Ribble Valley Borough Council
Housing & Development Control

Application no: **3/2021/0556**

Address: **74 Higher Road Longridge PR3 3SY and land to the rear**

Proposal: **Application for reserved matters consent (appearance, scale, landscaping and layout) pursuant to outline planning consent (ref 3/2016/1082) for the demolition of 74 Higher Road and construction of up to 123 houses on land to the rear.**

1800mm close boarded fence including 300mm concrete gravel board

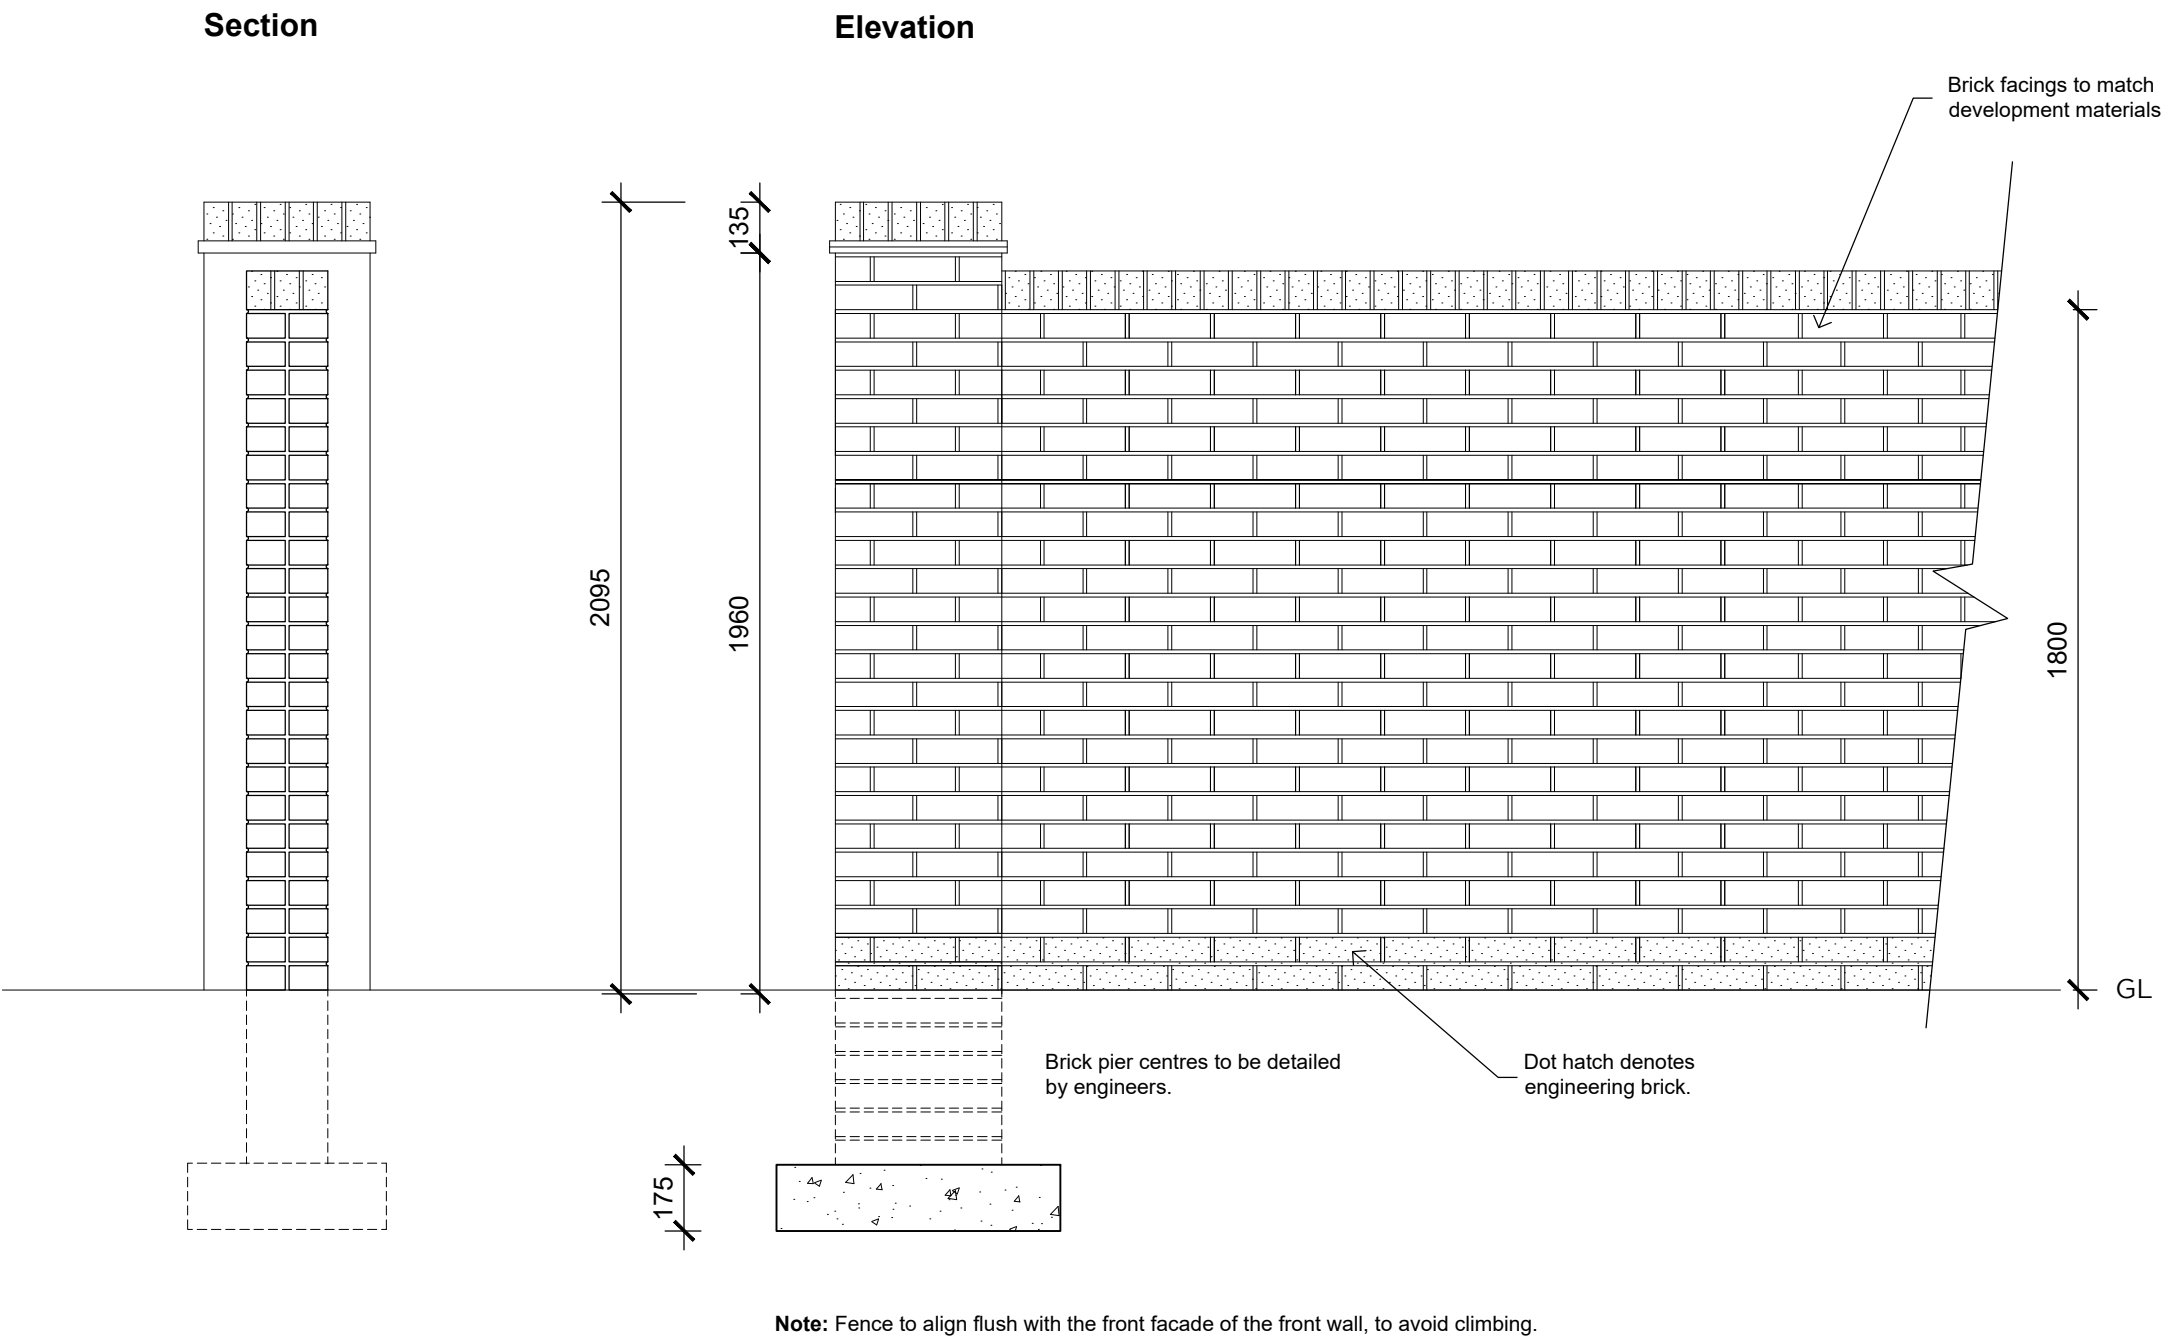
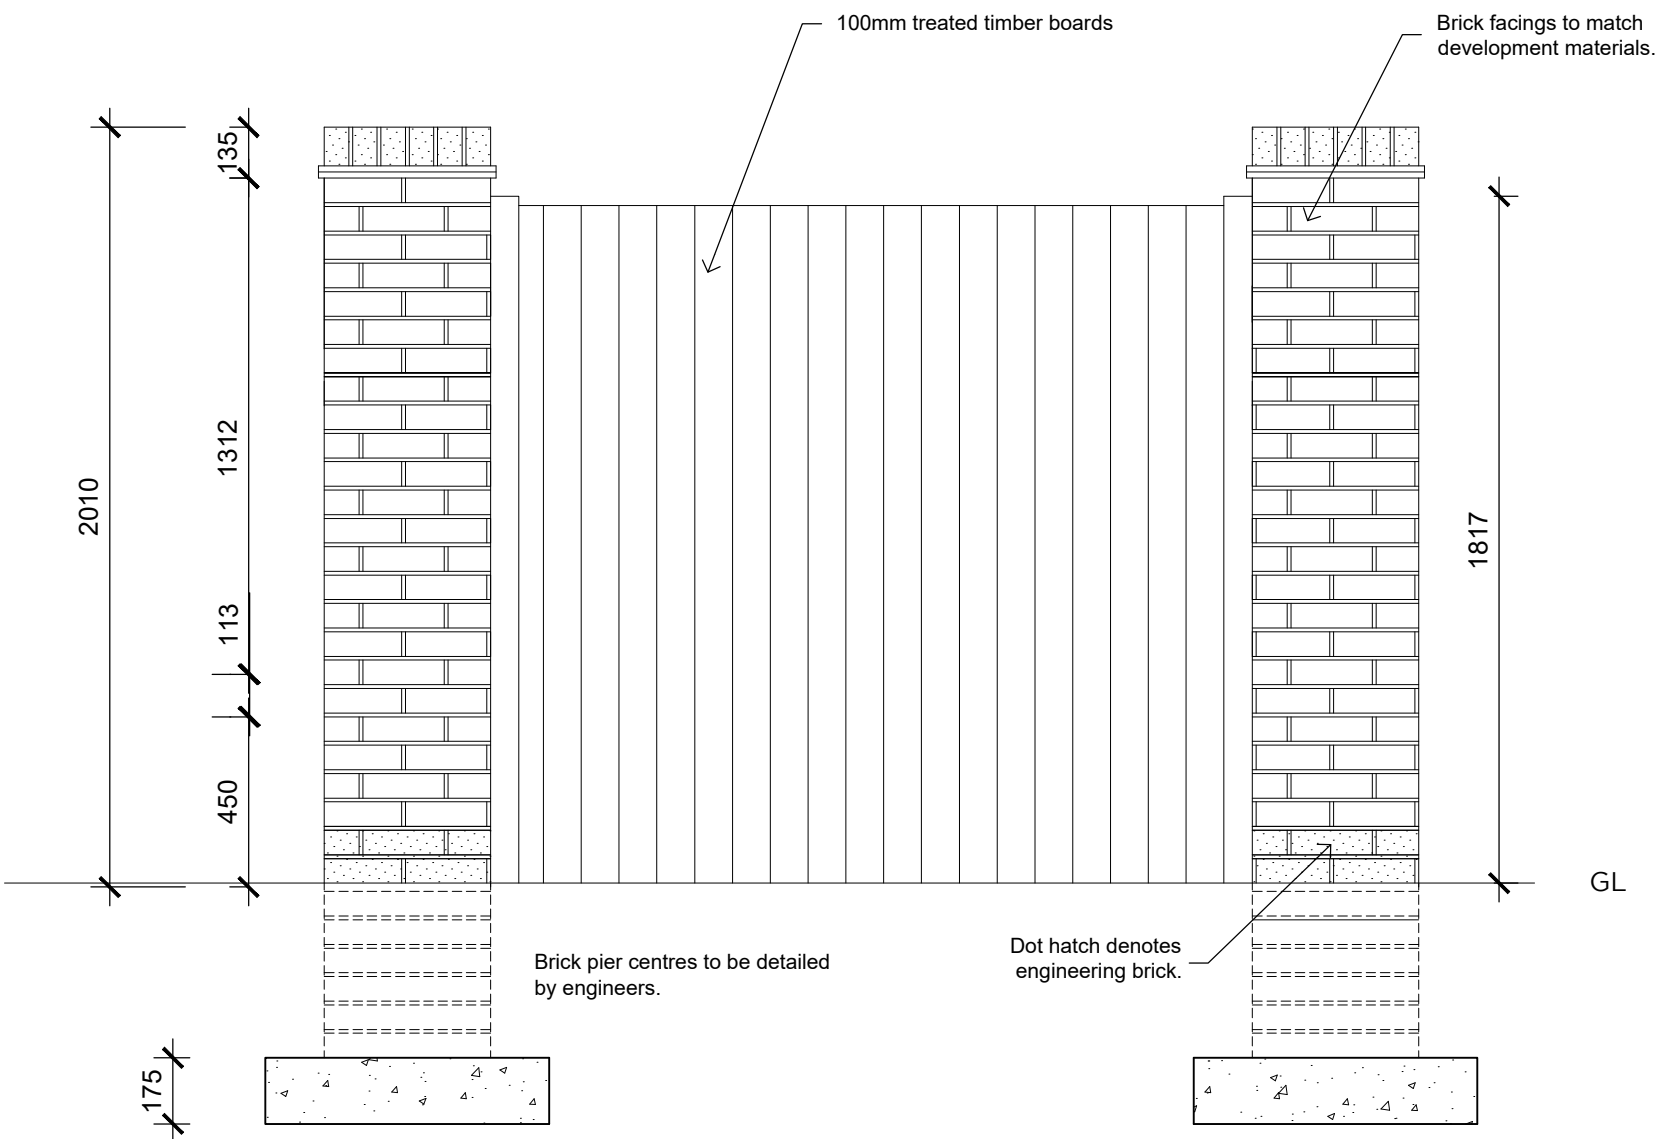
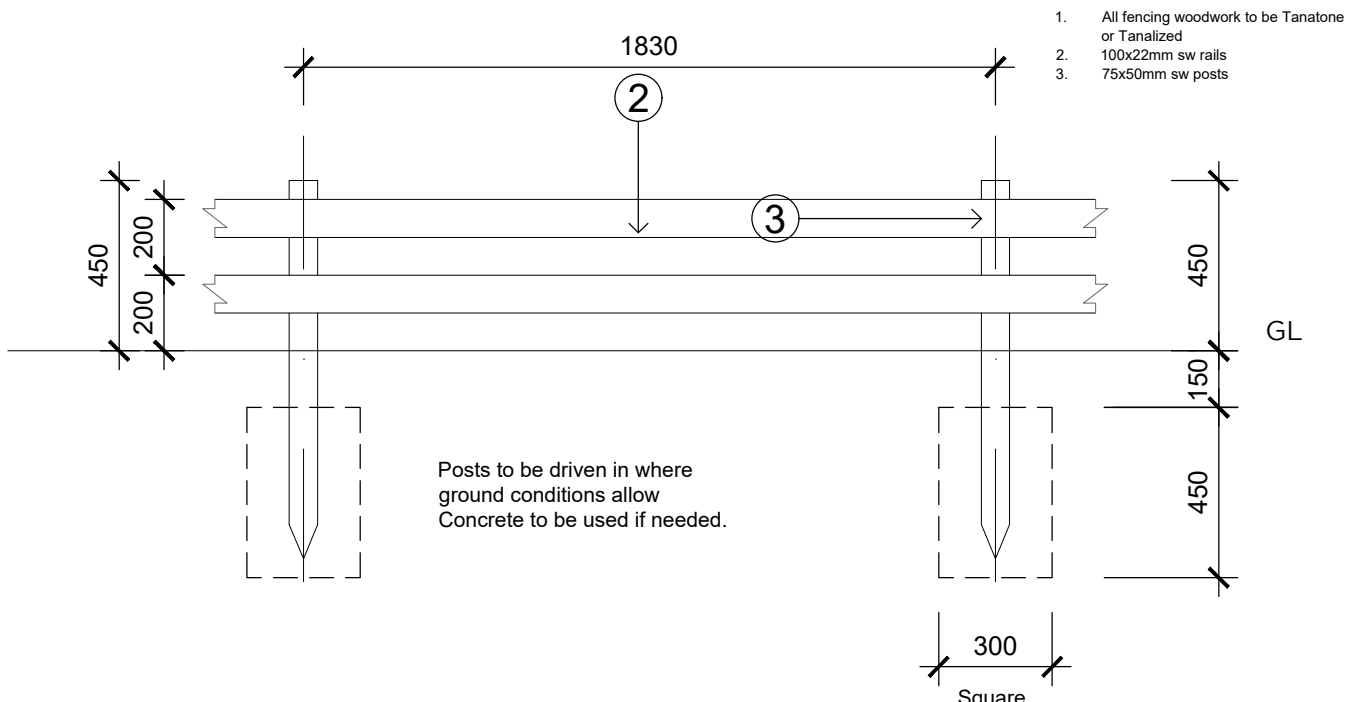
The LHA have also reviewed MPSL drawing number 03 Rev B titled "Boundary Treatment Layout" and require the 1.1m high railing provided at Plots 1, 2, 5, 6, 7, 8, 9, 10, 22 and 23 is reduced in height to 0.9m. The height should be reduced where the railing is located within each Plots visibility splay.
